## Conversation with Deb Andrews, 3/20/2018, re. 415 Cumberland Avenue

**A2.01**

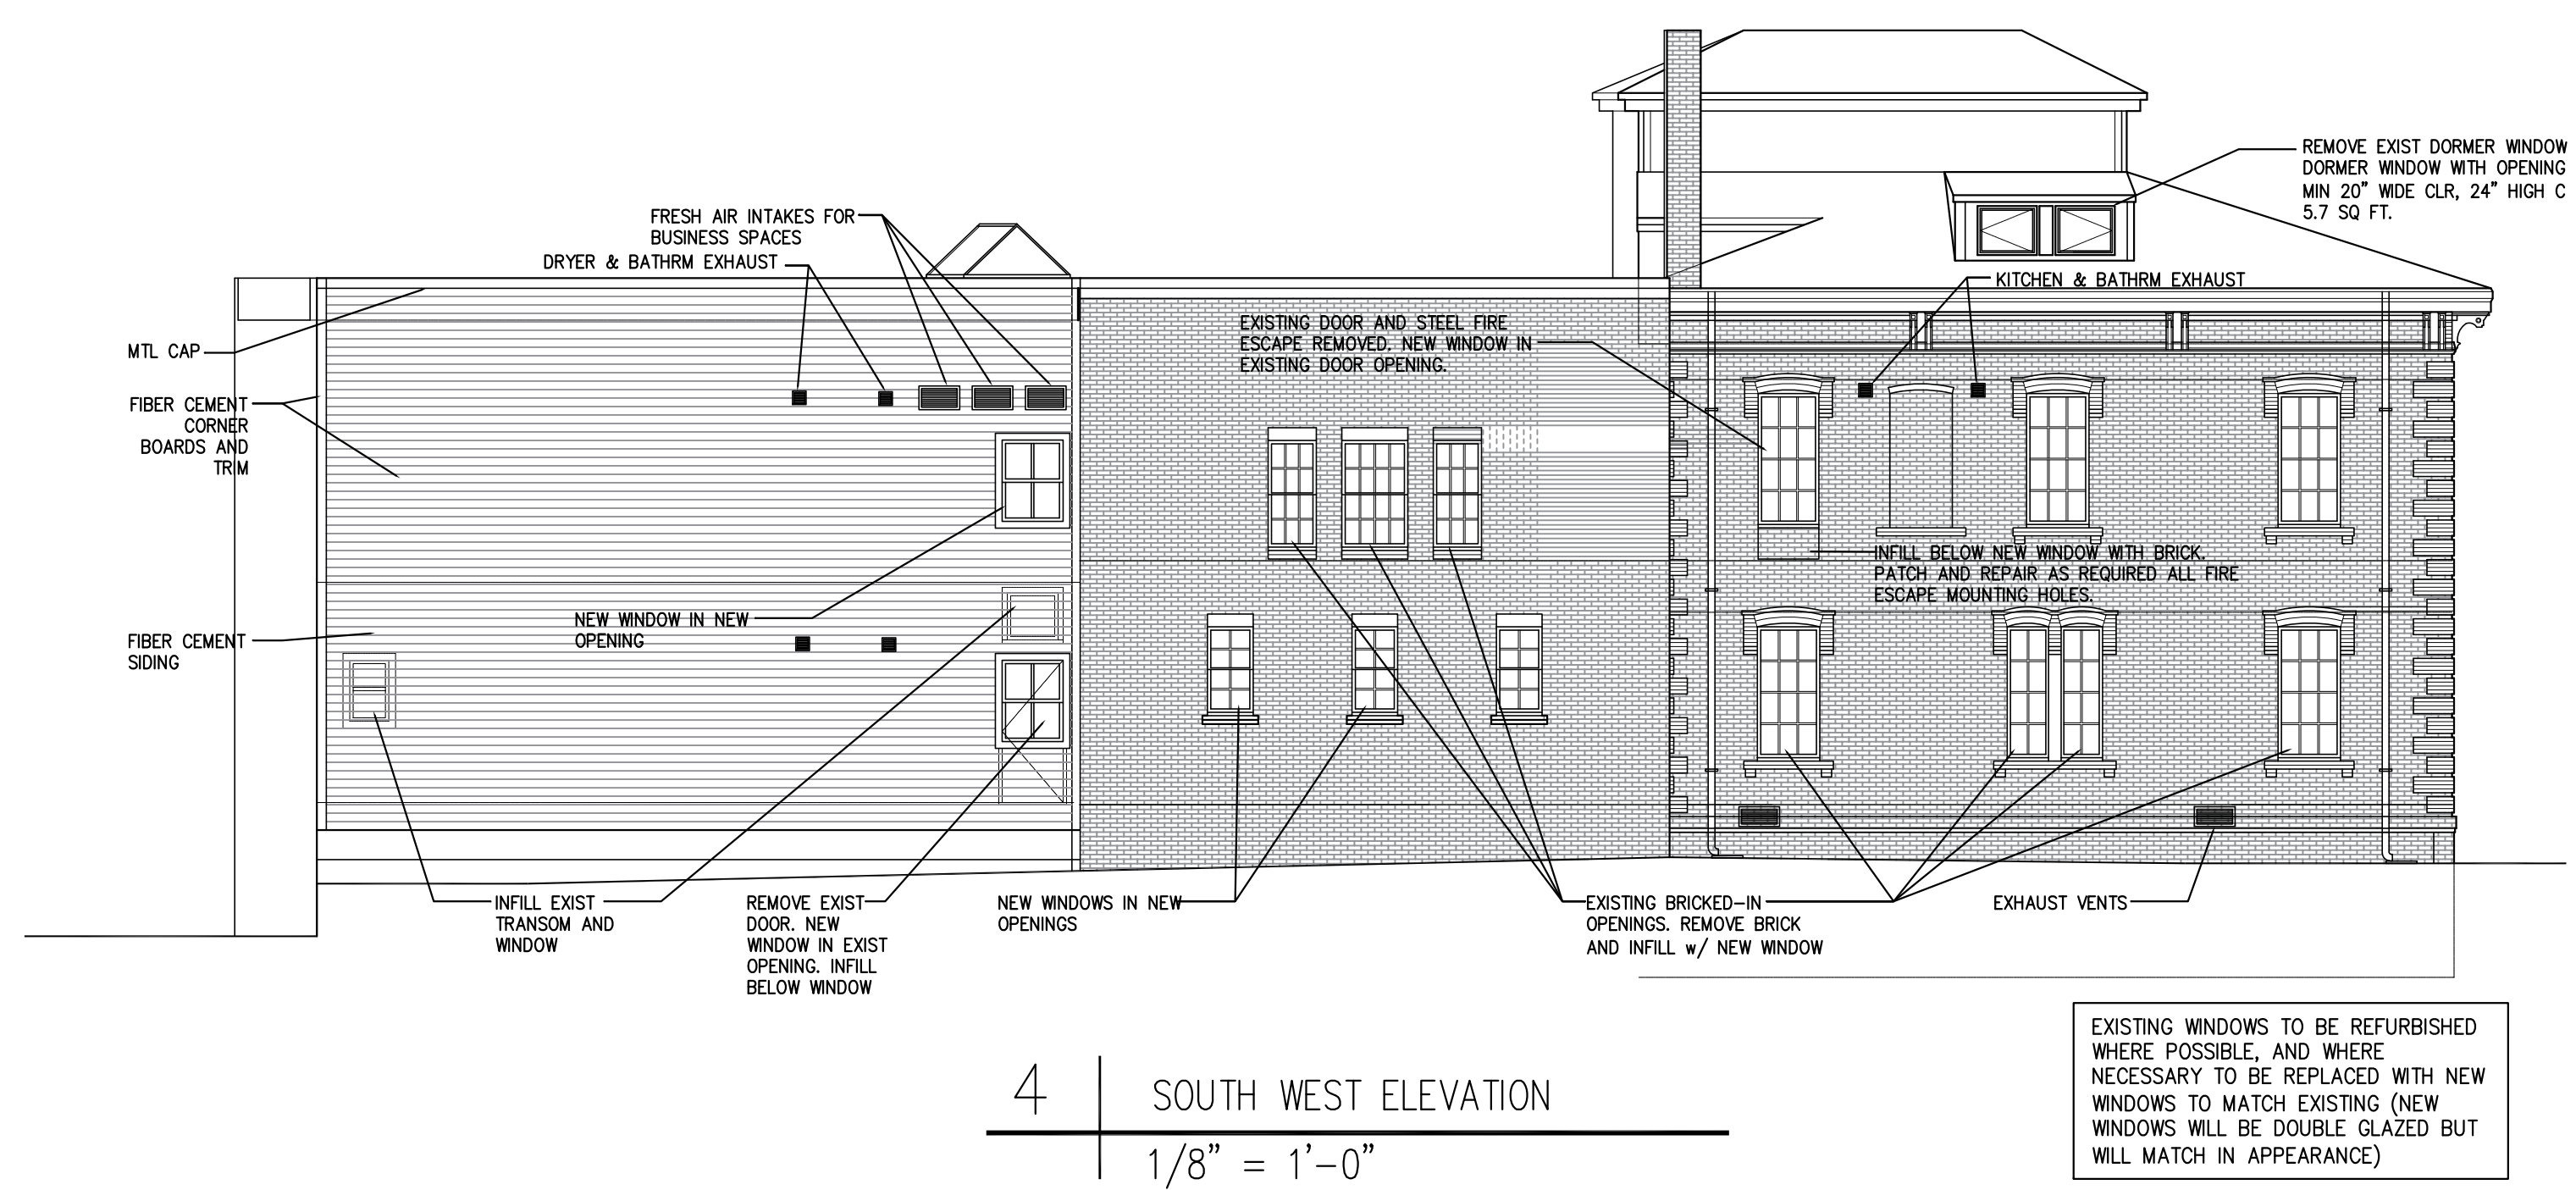
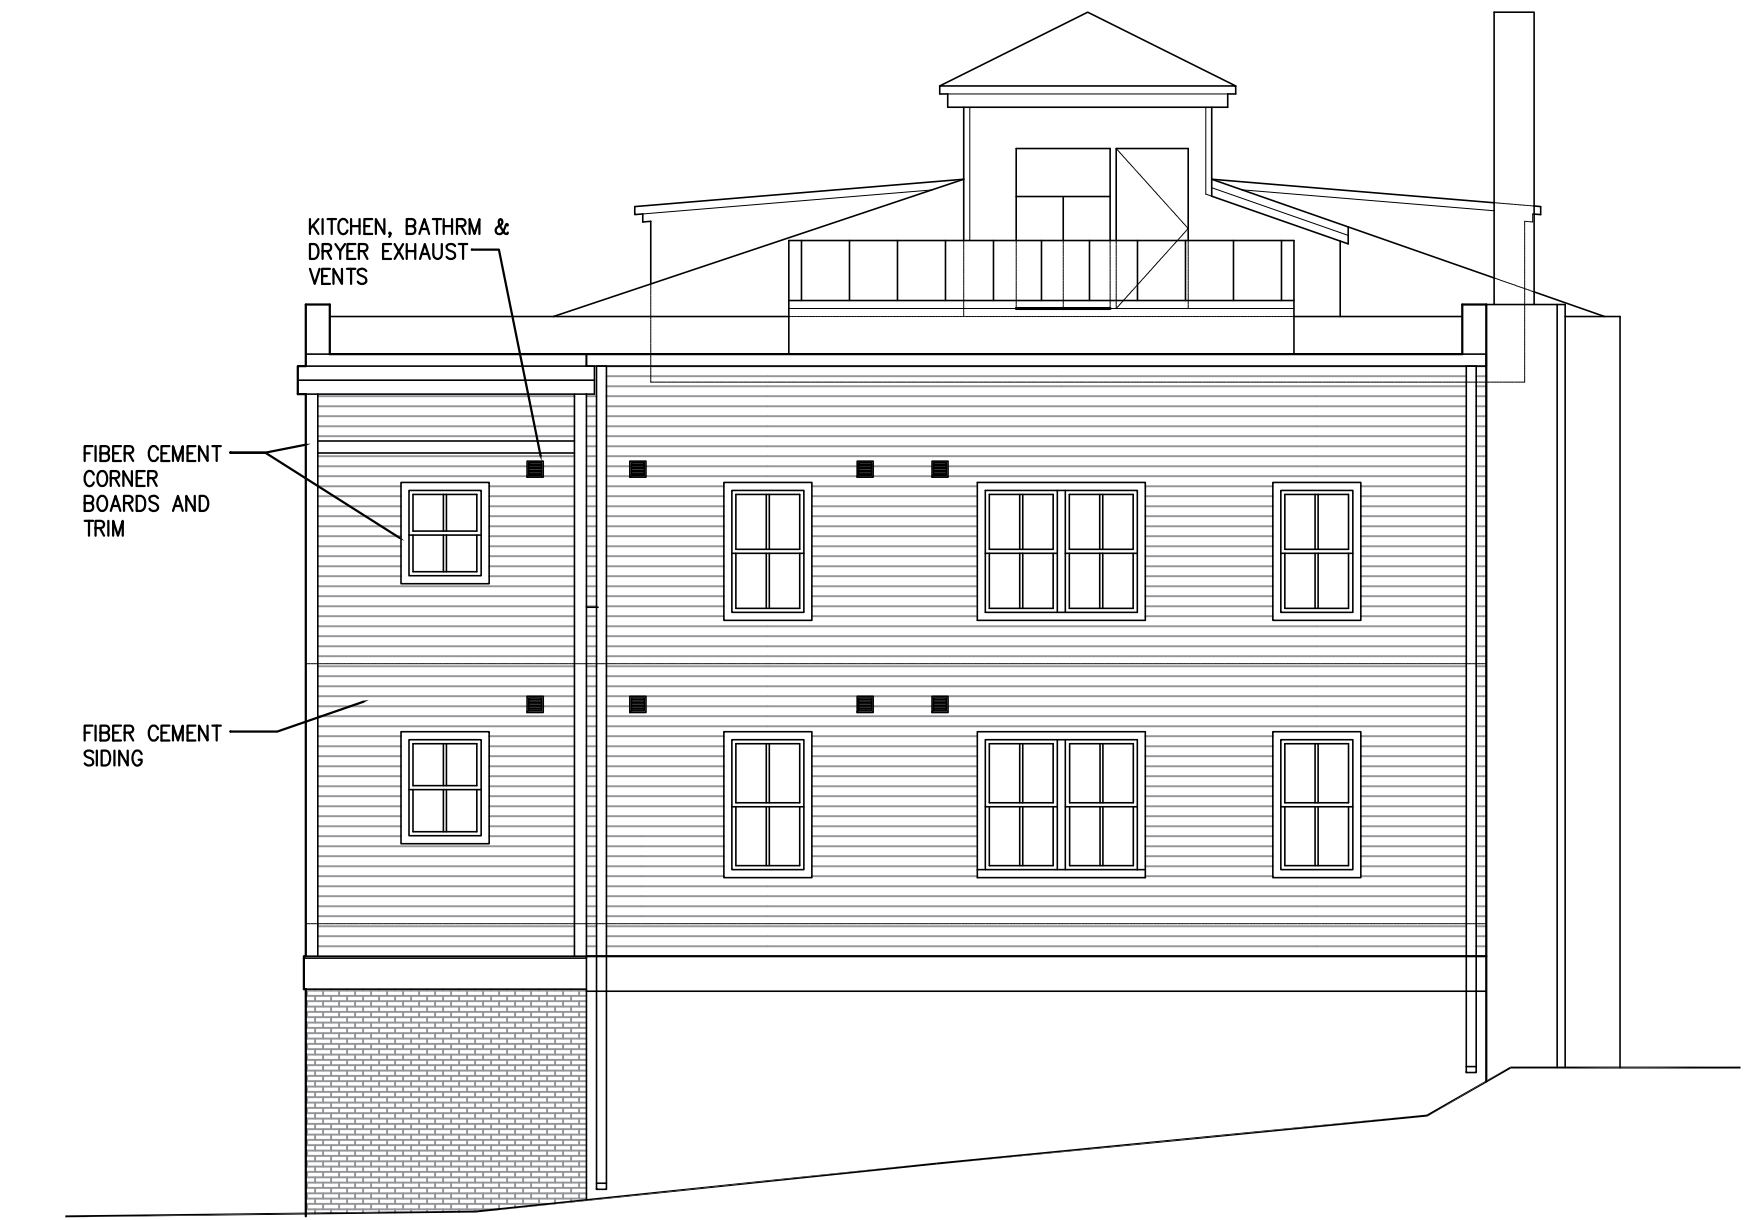
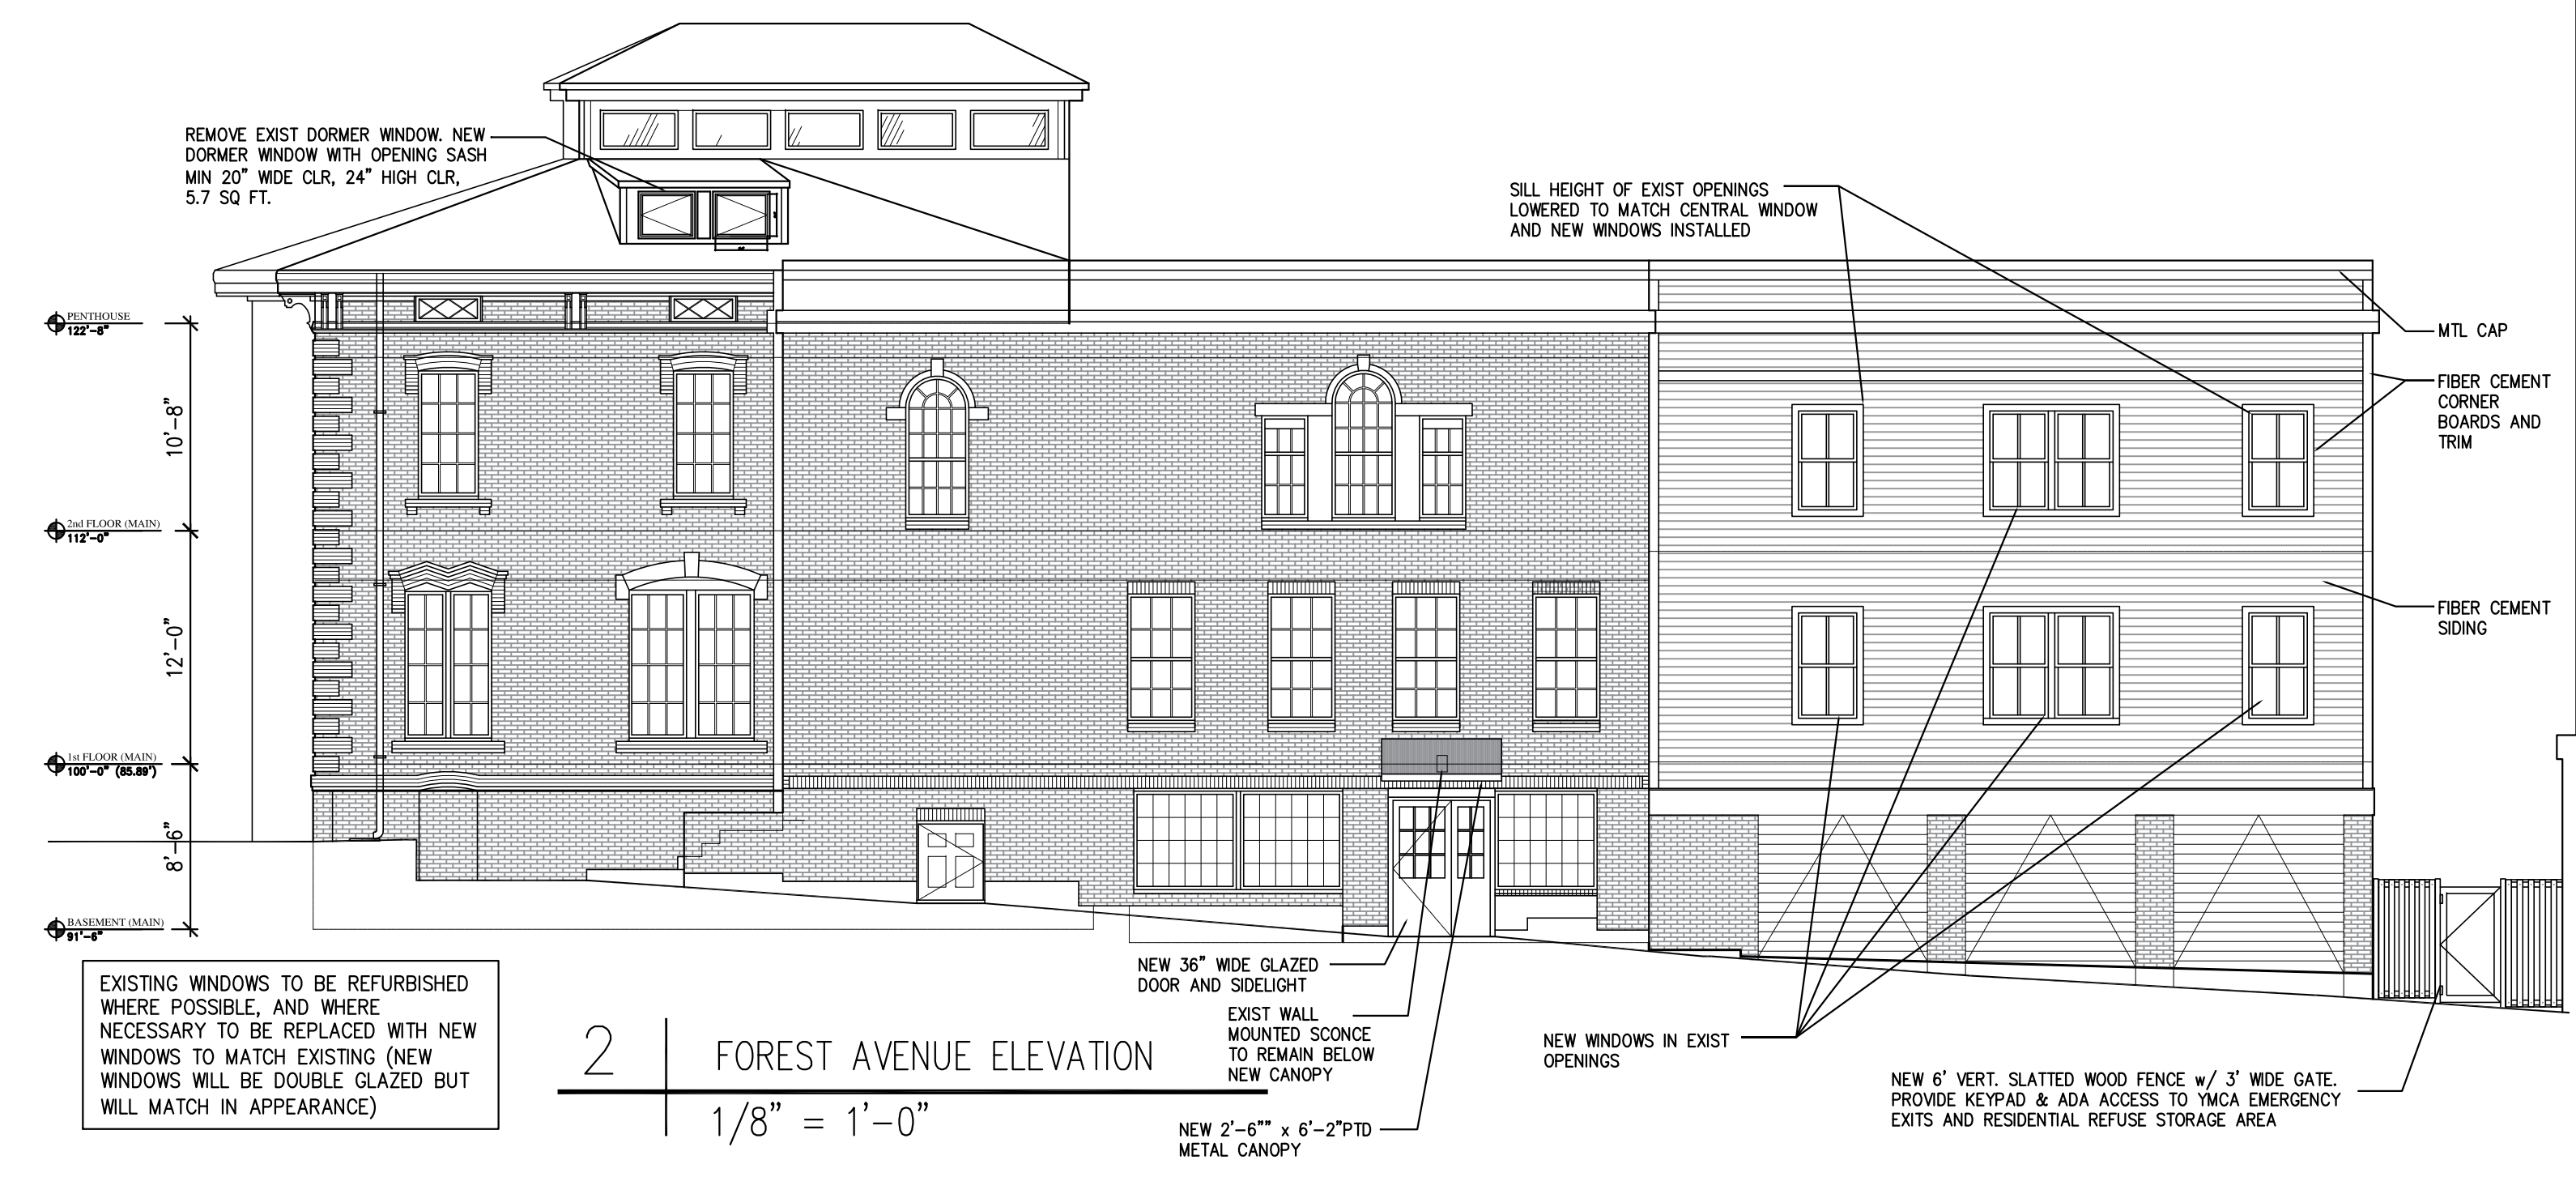
Request details on new windows. What are the materials? Windows should feature simulated divided lites with applied exterior muntins, at a minimum. Also, which windows will be repaired/replaced?

Request details regarding window moldings: will brick moldings be replicated in aluminum trim on other, new windows?

Why are two windows on the northwest elevation not the same height as all other windows on the northwest elevation and Forest Avenue elevation? Ideally these will match.

Request details regarding finishes. Painted finish of Hardie plank should not be high contrast, nor should relationship of trim to body of building be high contrast.

What is reveal / ttw of Hardie plank? (Reveal should be less than 6.”)

Hardie plank should be installed smooth side out (please note on plans).

Exhaust vents should be painted to match surrounding material (brick or Hardie plank siding).

Hardie plank at top of building parapets on Forest Avenue and southwest elevations seem strange – the treatments / bands along the top of the building’s middle section should be continued.

Will garage doors be replaced? If so, materials / details requested.

Request details regarding proposed new door on Forest Avenue, especially regarding material and panelization.

Coal chute should be retained, not removed or covered.
